Consultation Response from KC Highways
2019/91141 adj, 320, New Hey Road, Oakes, Huddersfield, HD3 4GQ
Outline application for erection of one detached dwelling
Date
Responding Officer: MB
Responding Ref: 2-19NW-7
Responded: 25/04/2019

This application seeks outline approval to the erection of one detached dwelling at land adjacent to 320, New Hey Road, Oakes, Huddersfield.

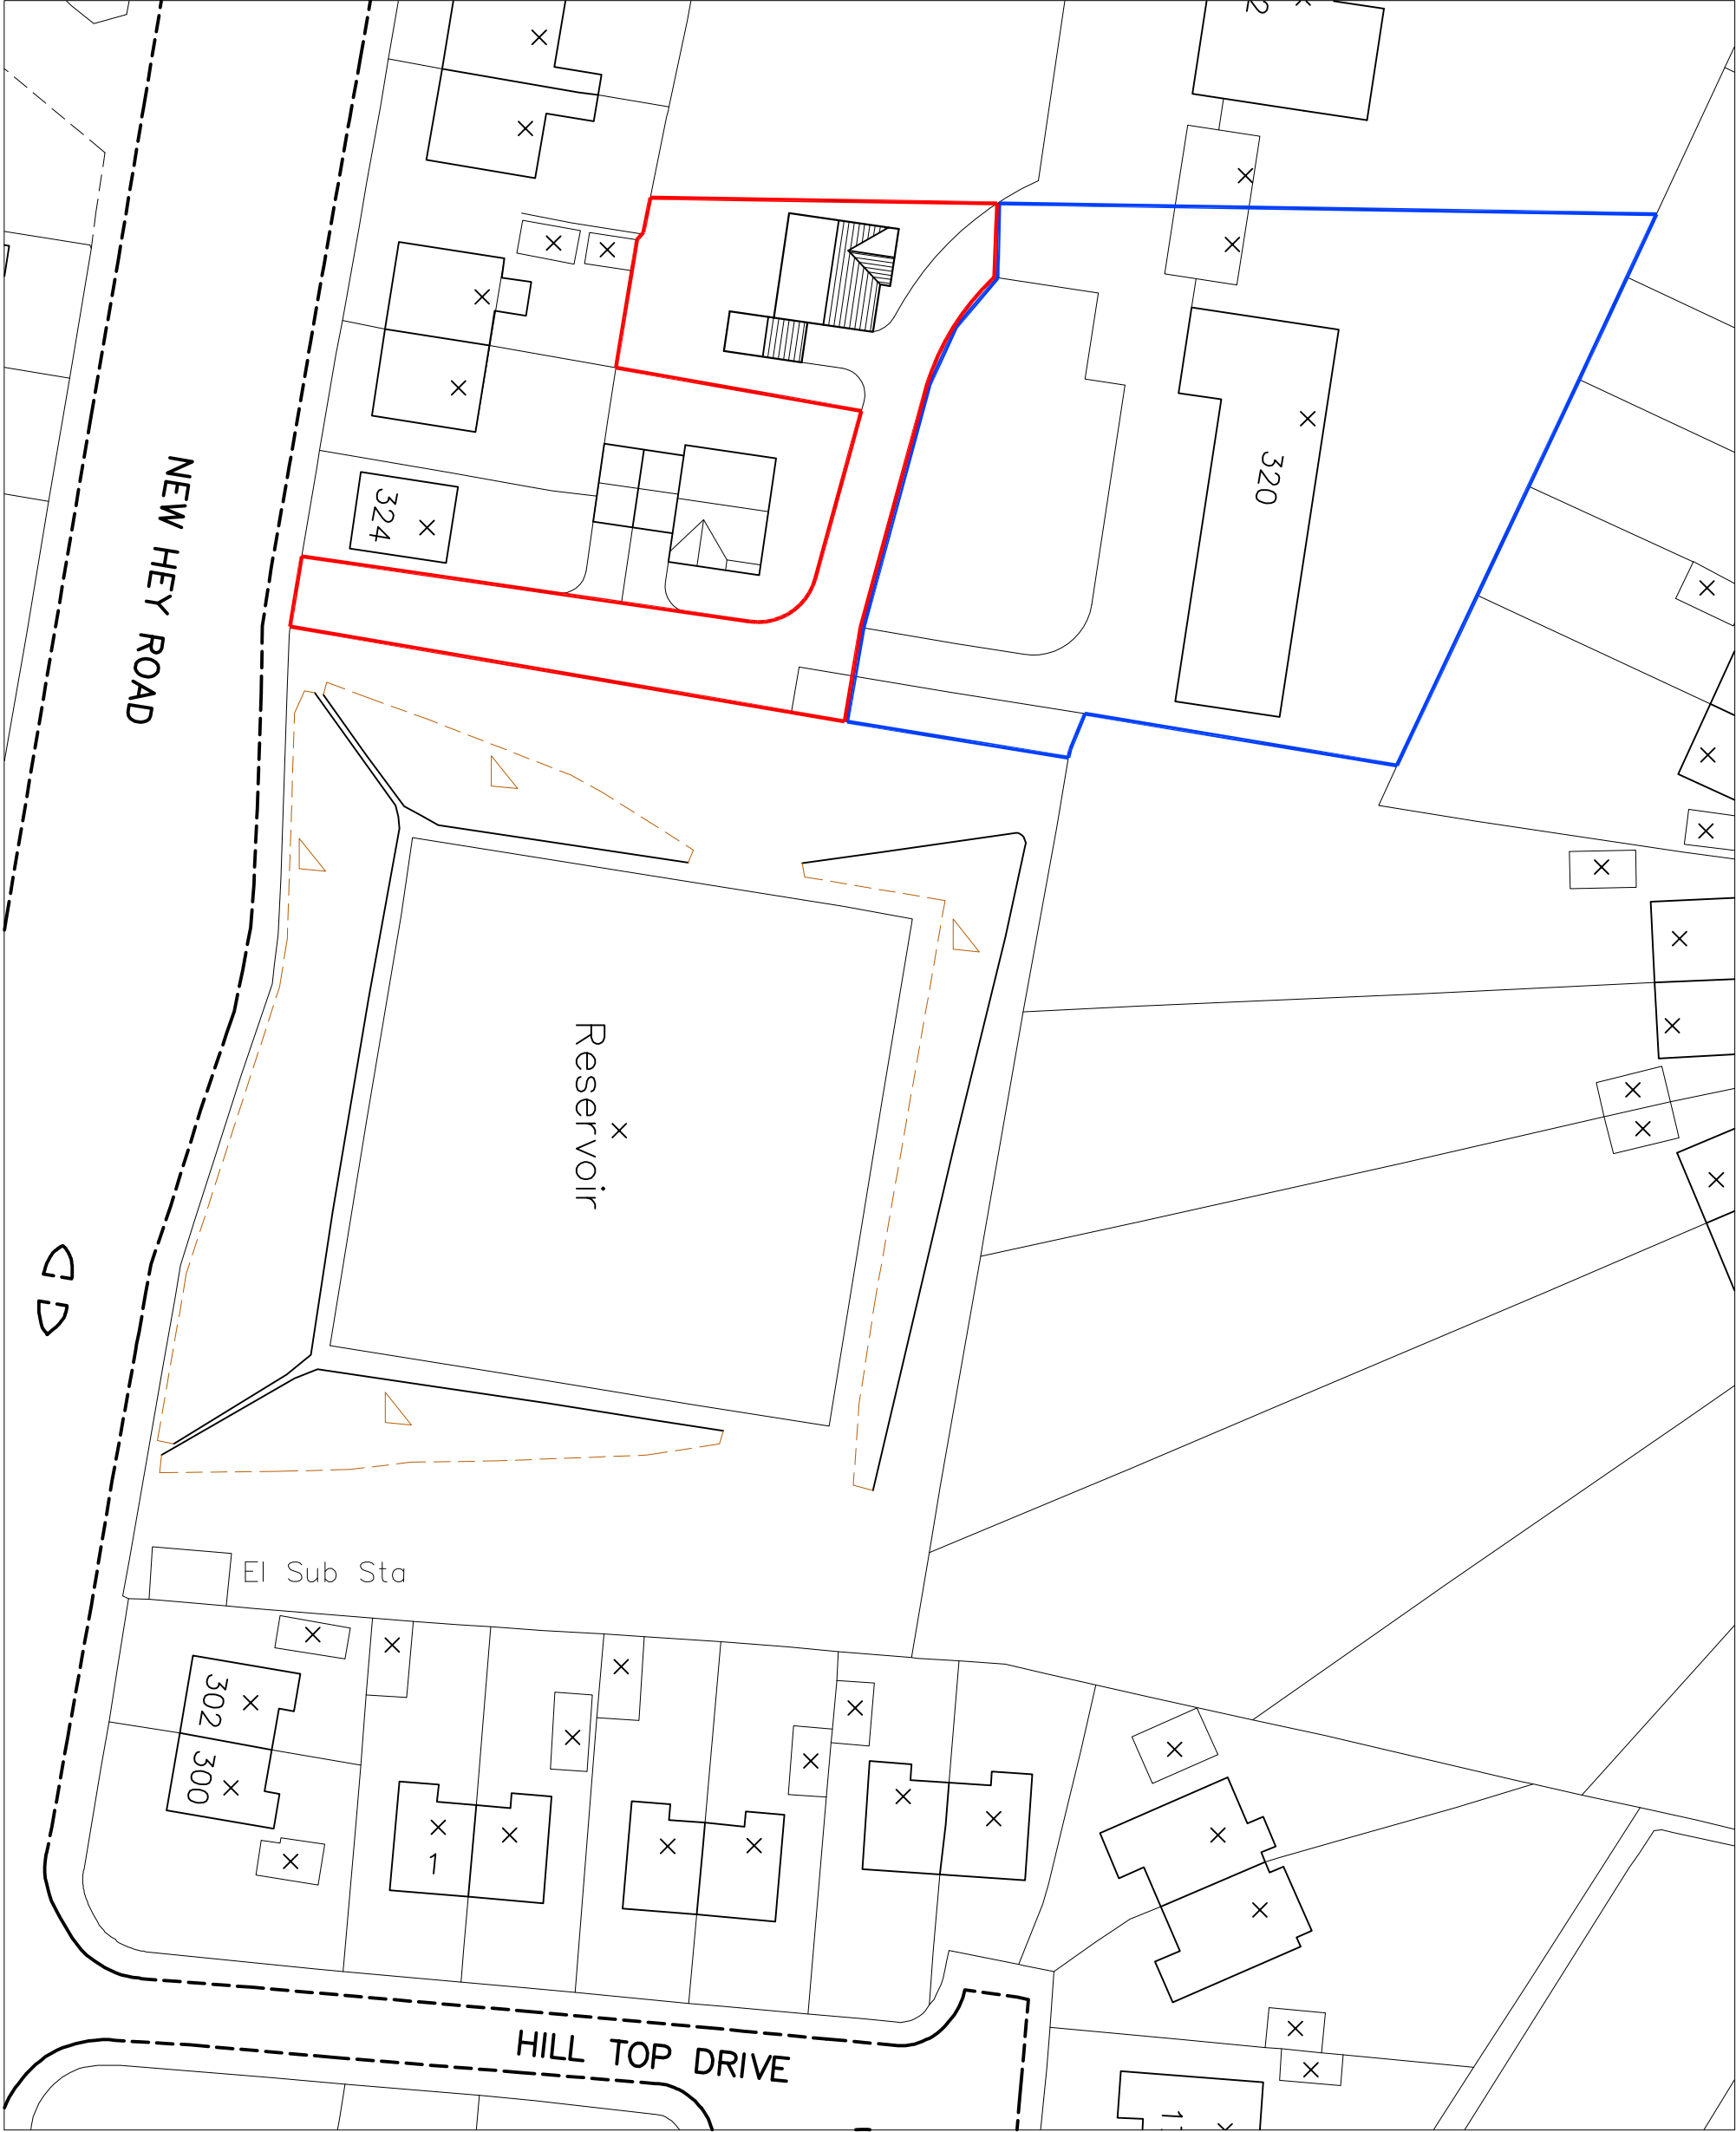
Plan number 1895/01 shows a detached dwelling with attached garage to the side and a single parking space on a proposed driveway to the front of the garage.

Given the previous approval and that this proposal will result in only 5 dwelling being served by the existing private driveway Highways Development Management have no objection to these proposals and have no wish to resist the granting of planning permission.

Prior to the development being brought into use, the approved vehicle parking areas shall be surfaced and drained in accordance with the Communities and Local Government; and Environment Agencies 'Guidance on the permeable surfacing of front gardens (**parking areas**)' published 13th May 2009 (ISBN 9781409804864) as amended or superseded; and thereafter retained throughout the lifetime of the development.
